The Secretary
NSW Department of Planning, Industry and Environment

10 April 2020

I refer to the Department's below email of 1 April 2020 regarding the notice of exhibition of the Environmental Impact Statement (EIS) for State Significant Development SSD 10383 at 2 Darcy Road, Westmead (Lot 1 DP 1095407, Lot 1 DP 1211982) for Westmead Catholic Community Education Campus – 'Primary school with capacity for approximately 1,680 students, new Parish church, early learning centre, multi-storey car park and drop off zone and landscaping'. Submissions need to be made to the Department by 29 April 2020.

Subject: NSW Planning, Industry & Environment Request for SEARs State Significant Development SSD 10383 Westmead Catholic Community Education Campus

Site Plan from Endeavour Energy's HxGN NetWorks Core NetViewer Master Facility Model

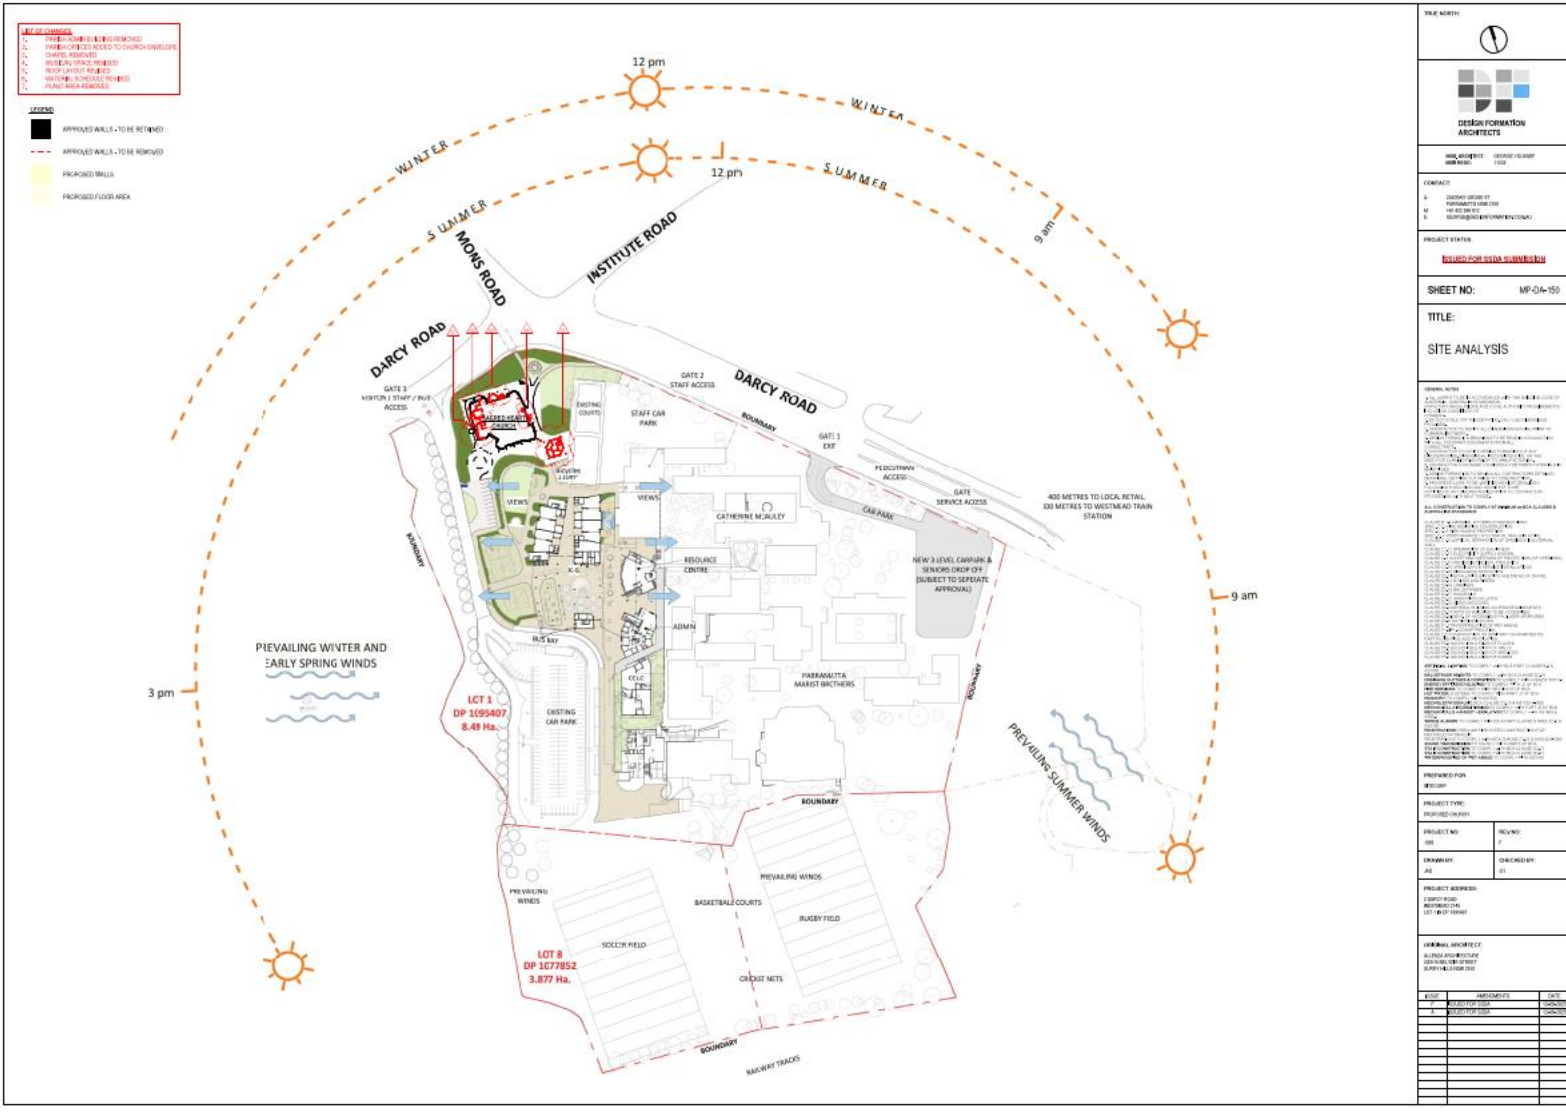
As shown in the below site plan from Endeavour Energy's G/Net master facility model (and extract from Google Maps Street View) there:

- Two easement over the site benefitting Endeavour Energy (indicated by red hatching) for padmount substations no.s 7763 and 29361 (indicated by the symbols ).
- Low voltage and 11,000 volt / 11 kilovolt (kV) high voltage underground cables to the road frontage.

The two existing padmount substations on the site:

- No. 7763 currently has 4 customer connection points servicing 7 premises.
- No. 29361 currently has 1 customer connection points servicing 2 premises.

With the exception of a customer connection point for Roads and Maritime Services from padmount substation no. 7763, both padmount substations only service the existing Campus. Neither of the two padmount substation is likely to have sufficient spare capacity to supply a significant urban development. Given the size of the proposed development an extension and/or augmentation of the existing local network is likely to be required. However the extent of the work required will not be determined until the final load assessment is completed. Endeavour Energy's preference is to alert proponents / applicants (and the Department) of the potential matters that may arise as further redevelopment of urban areas continues to occur.
